CIRCLE A SUBDIVISION FILING NO. 1

FINAL PLAT
CIRCLE A SUBDIVISION FILING NO. 1
JOB NO.: 70-072
DATE PREPARED: 07/15/2019
DATE REVISED:

MS-20-007

FINAL PLAT
CIRCLE A SUBDIVISION FILING NO. 1
JOB NO. 70-072
DATE PREPARED: 07/15/2019
DATE REVISED:

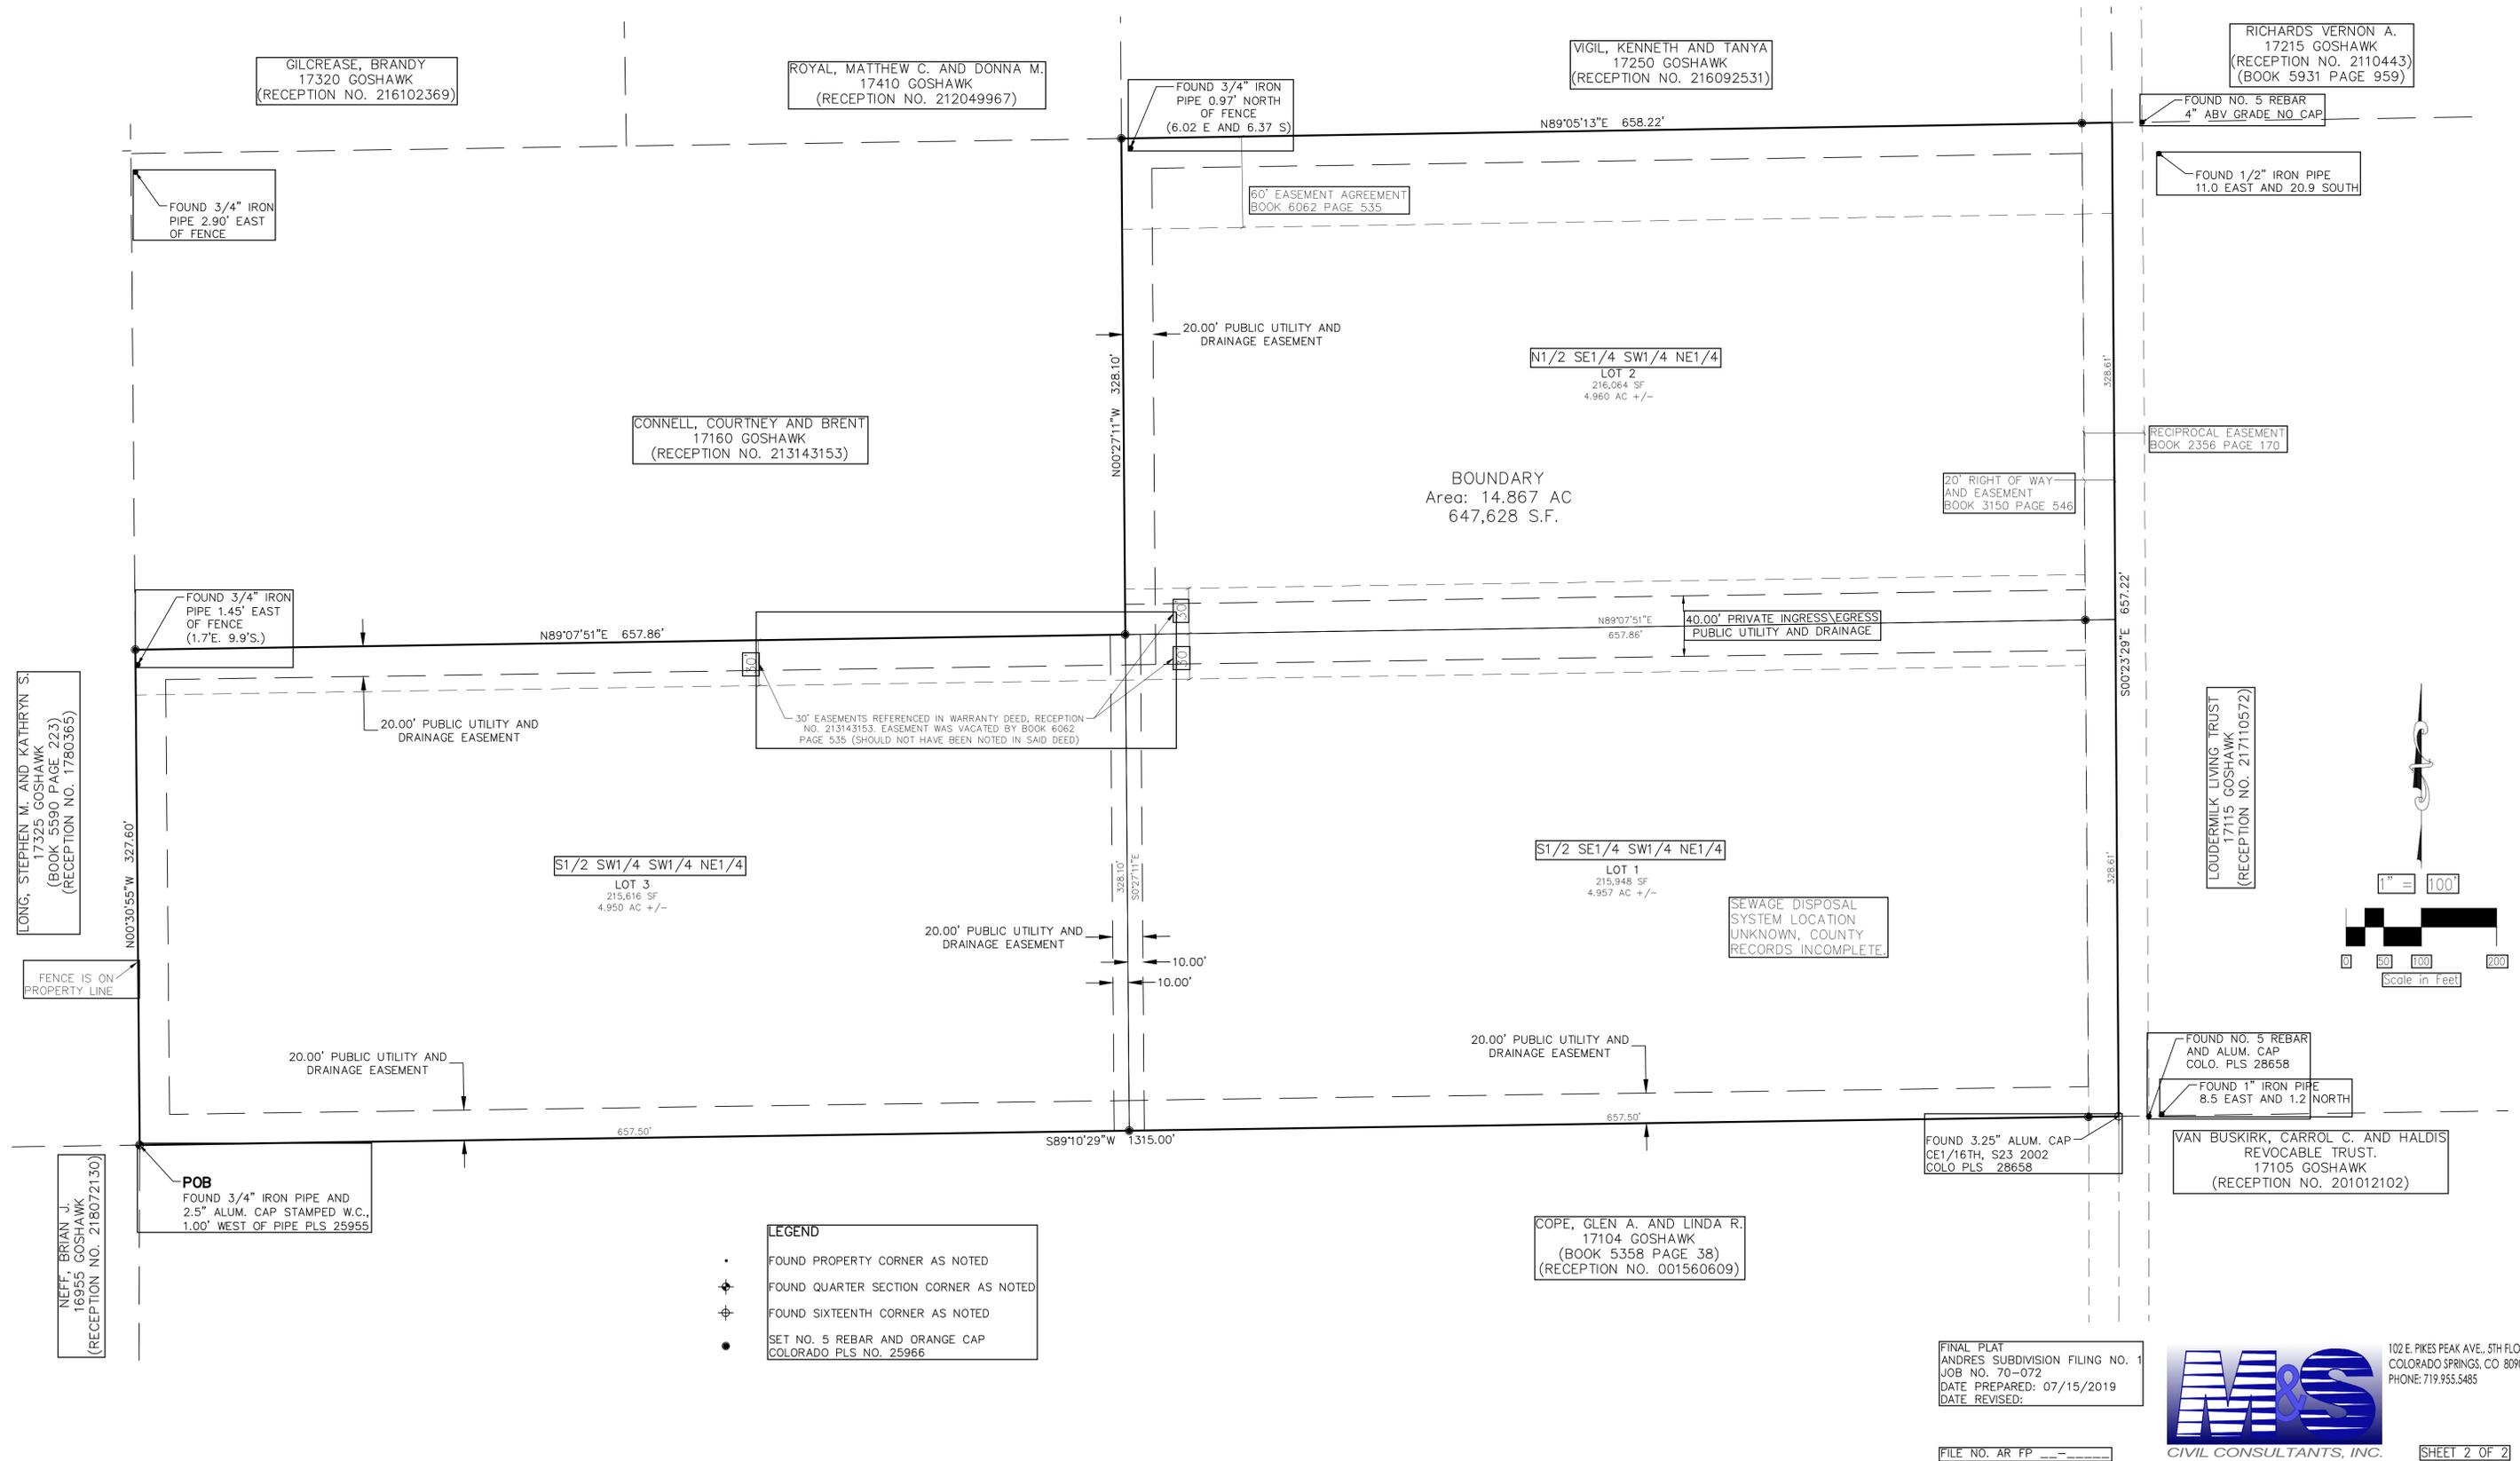
Please include the following notes:

Please revise this to simply say something to the effect of "Said lands contain 14.87 acres, MOL"

May want to include a brief description of said terms, provisions and agreements

This note may be subject to revision per County Attorney comments

Reference that this is the result of soils & geology conditions on the site.

Please revise per comment on legal description
